Ref 2022/0687 – Advertisement Consent Application

Proposal: Internally illuminated hanging and projecting signs set within unit frontage and privacy vinyl's applied to first floor windows

Address: Community Diagnostic Centre, The Glass Works, Barnsley, S70 1GW

Proposed Illuminated Projected Sign

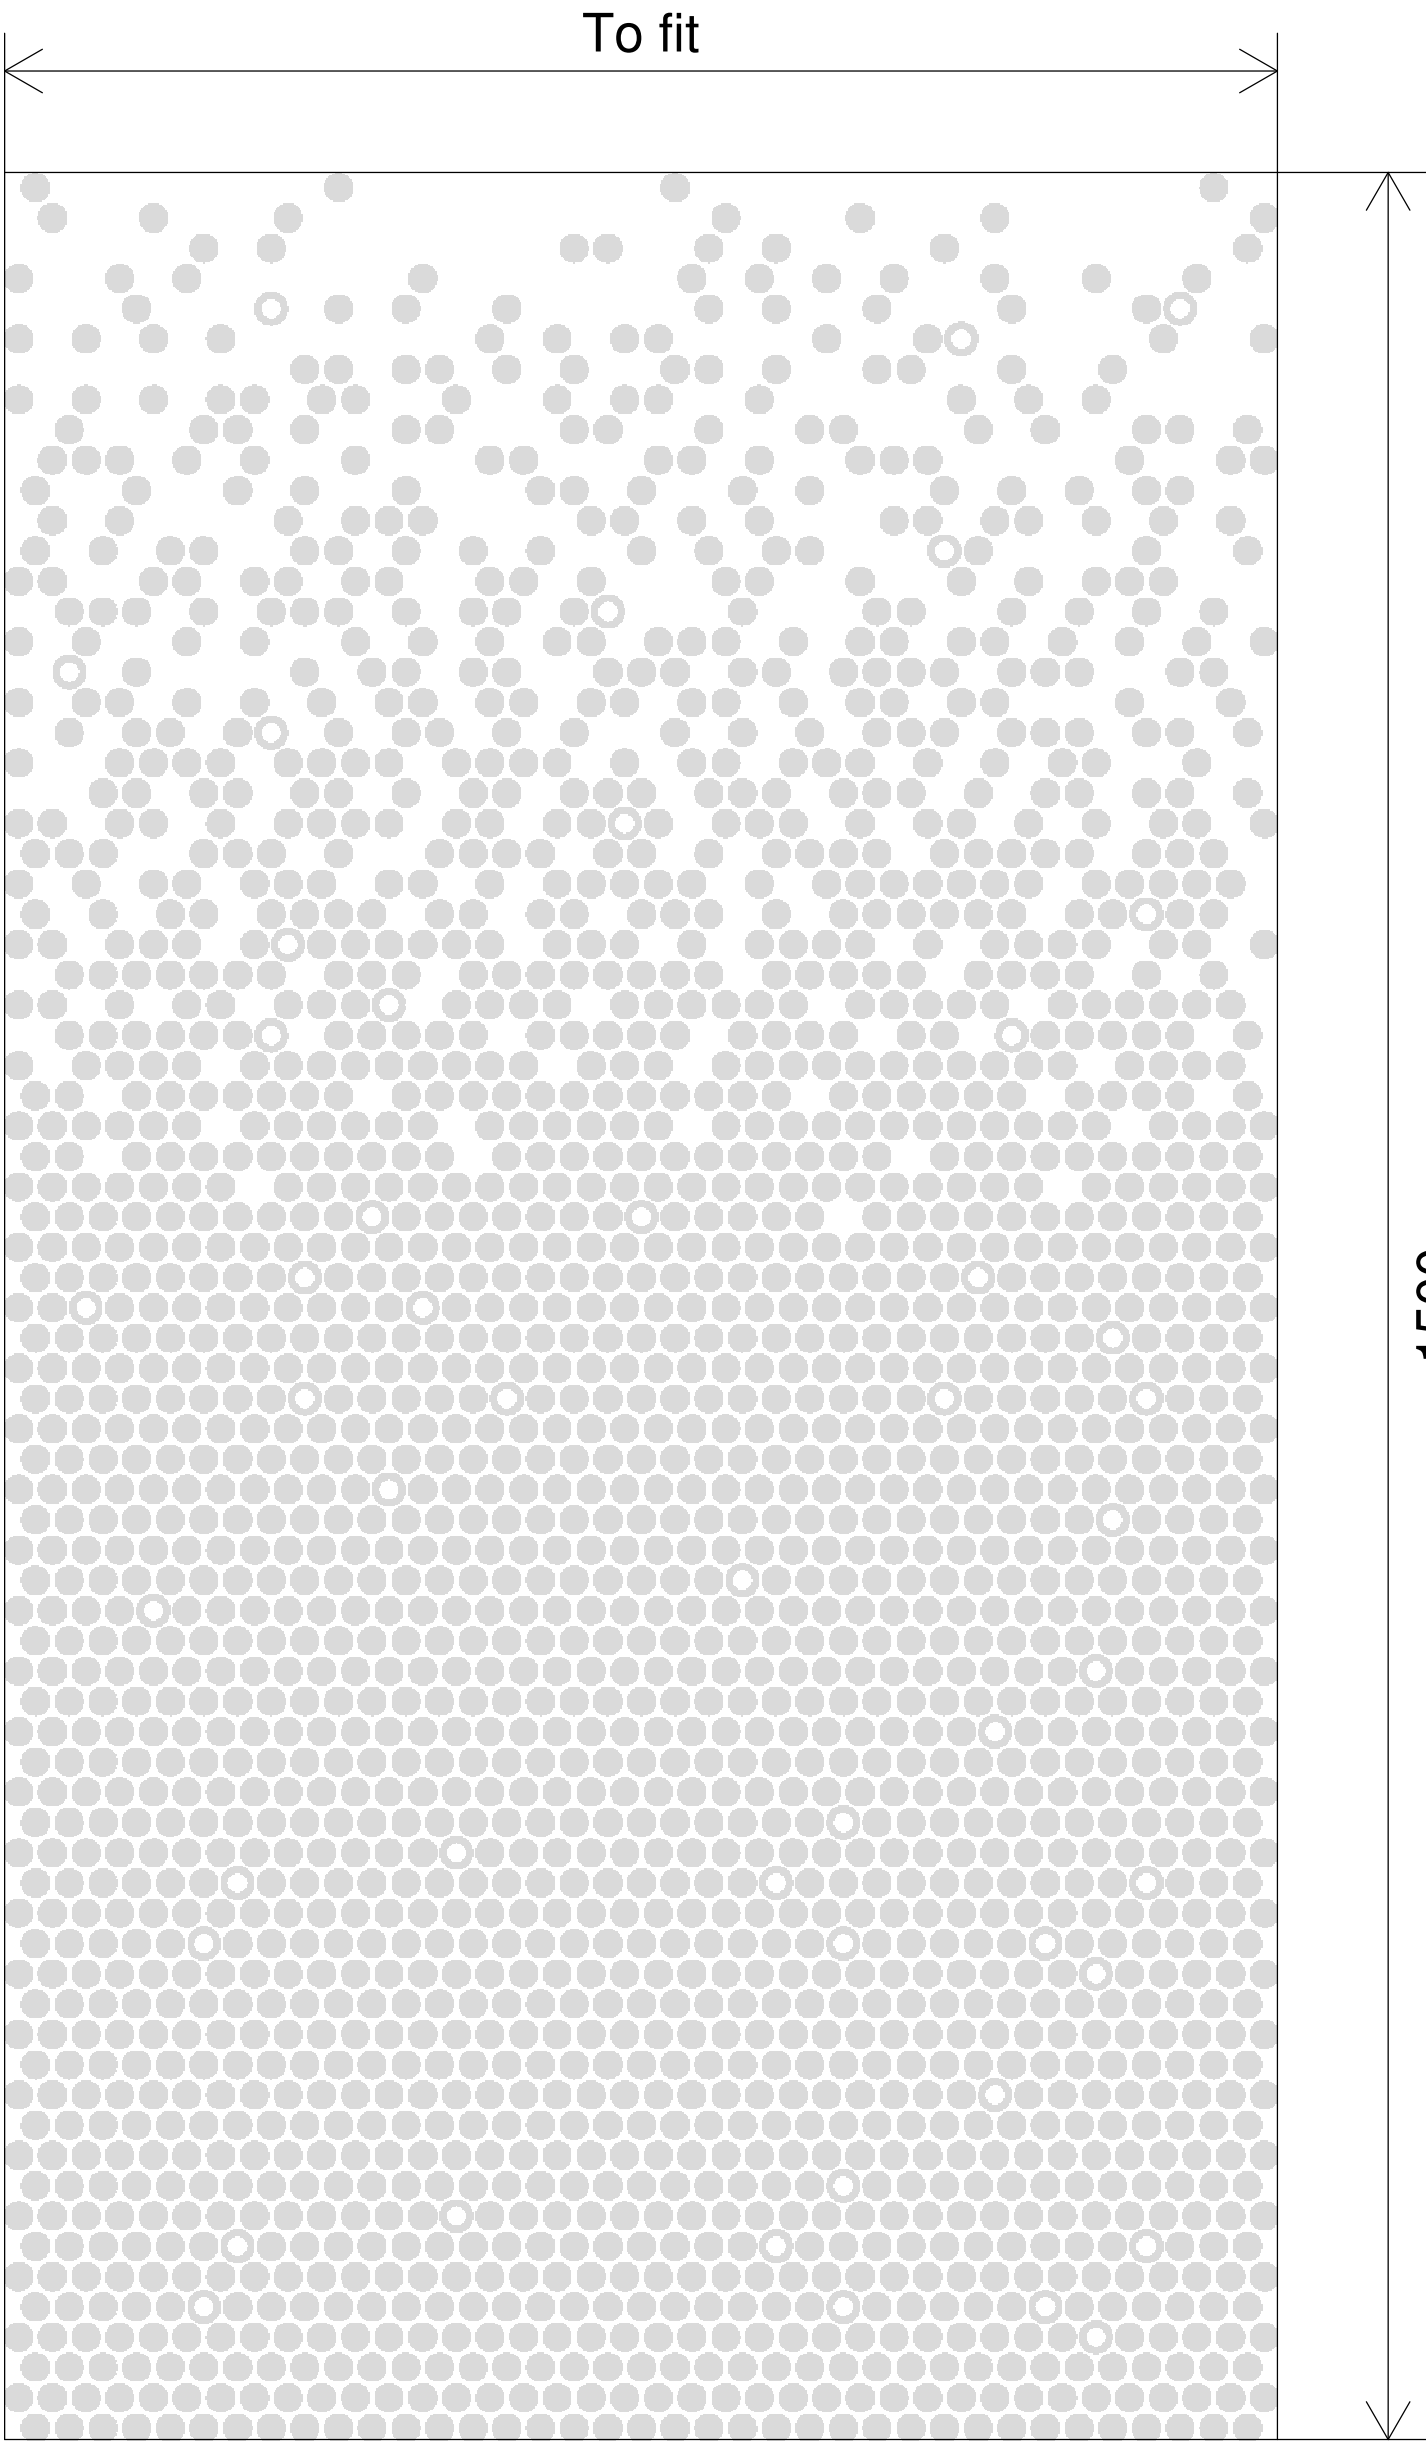
Design – Initial comments – I am fine with the hanging and projecting signs provided the projecting sign is fitted flush to the pillar and not with a connecting 'arm'. I note that the latter may have to be moved as it appears to conflict with an existing CCTV camera. Seeks clarification and amendments to the vinyl to secure transparency, an overriding theme of the Glass works shopfronts design guide

The internally hung and internally illuminated hanging sign is acceptable. Following adverse comments from the Design Officer, the application has been amended to move the location of the internally illuminated projecting sign which would otherwise have conflicted with an existing CCTV camera and to redesign the method of fixing such that it is fitted flush to the pillar. Both signs are proposed to have illumination of 600cd/m²

- The vinyl has been amended to maximise the amount of clear glass (and therefore transparency)
- The privacy vinyl has been removed from the ground floor unit
- The projecting sign now sits flush with the wall per other projecting signs around the development and has been moved to avoid a clash with an existing CCTV camera.
